Your ref: 3/2024/0726
Our ref: DC/24/2256
Date: 06-NOV-24

Location: Shackletons Garden Centre, Clitheroe Road, Chatburn, BB7 4JY.

Proposal: Approval of details reserved by conditions 11 (car park surface water drainage) & 17 (surface water drainage).

Title: PROPOSED DRAINAGE GENERAL ARRANGEMENT SHEET 1 OF 2

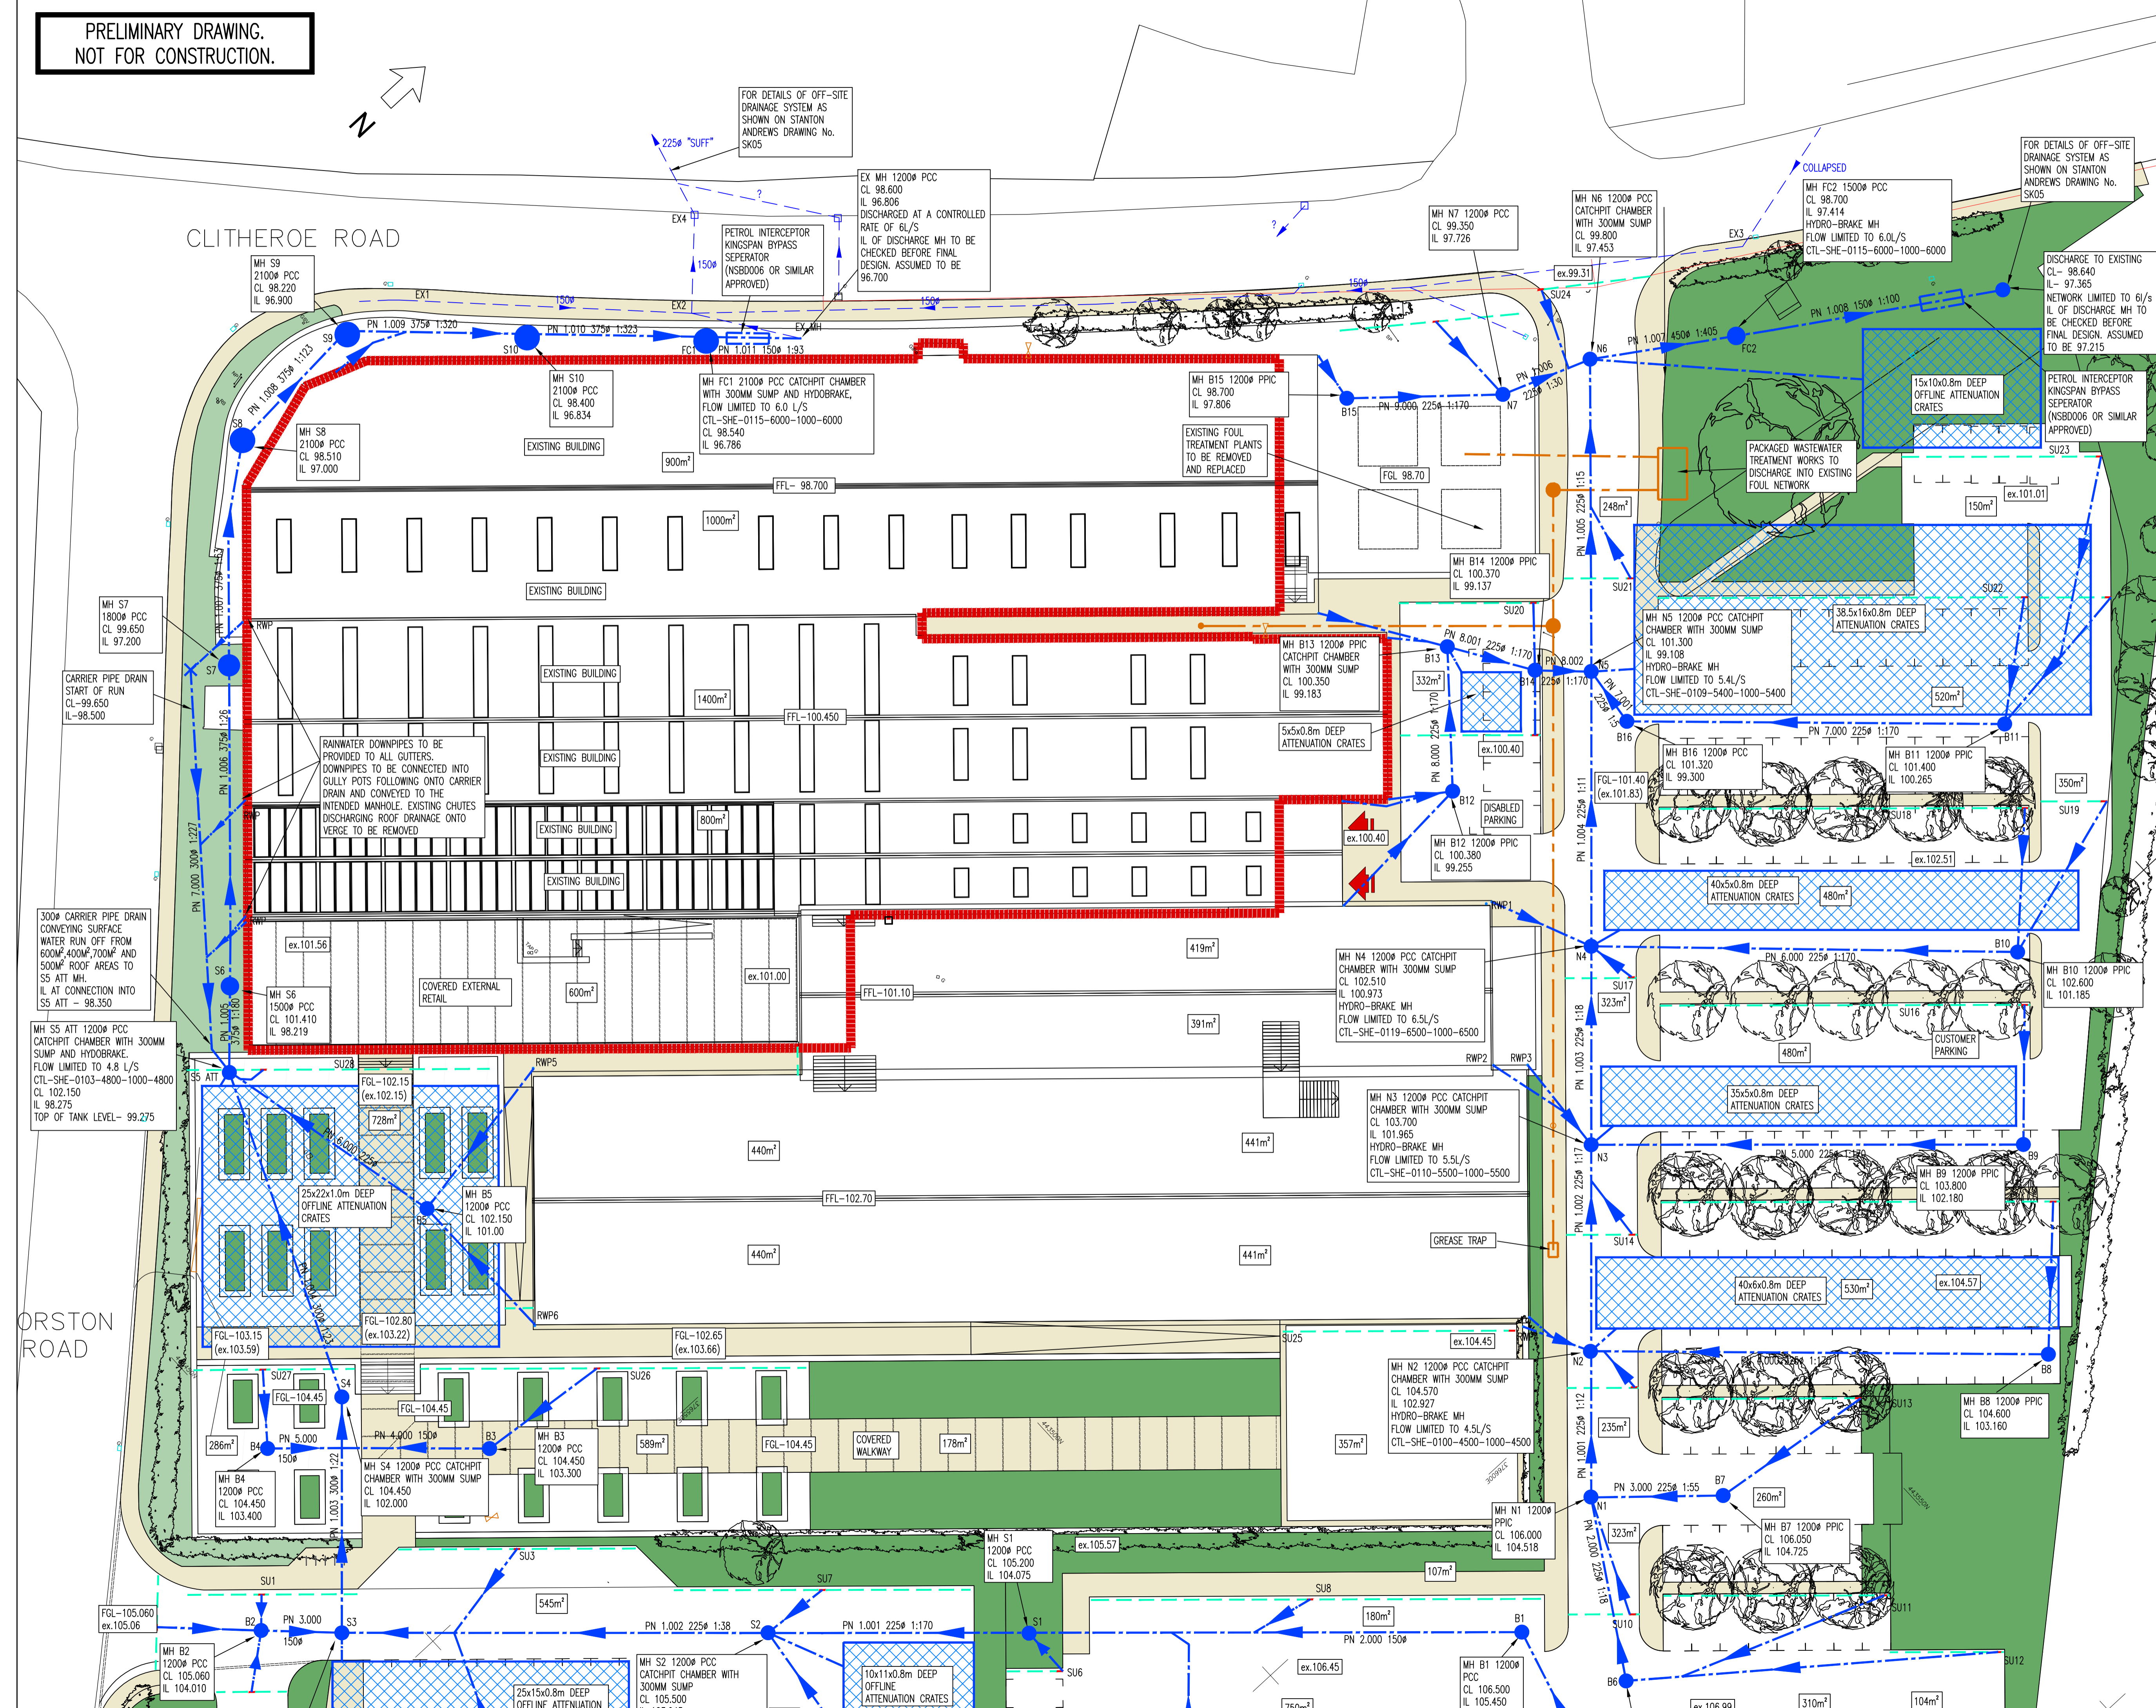
Further to our review of the submitted documents, United Utilities recommends that condition 11 & 17 are not discharged. This is because the drainage drawings do not show where the foul outfall ultimately discharges.
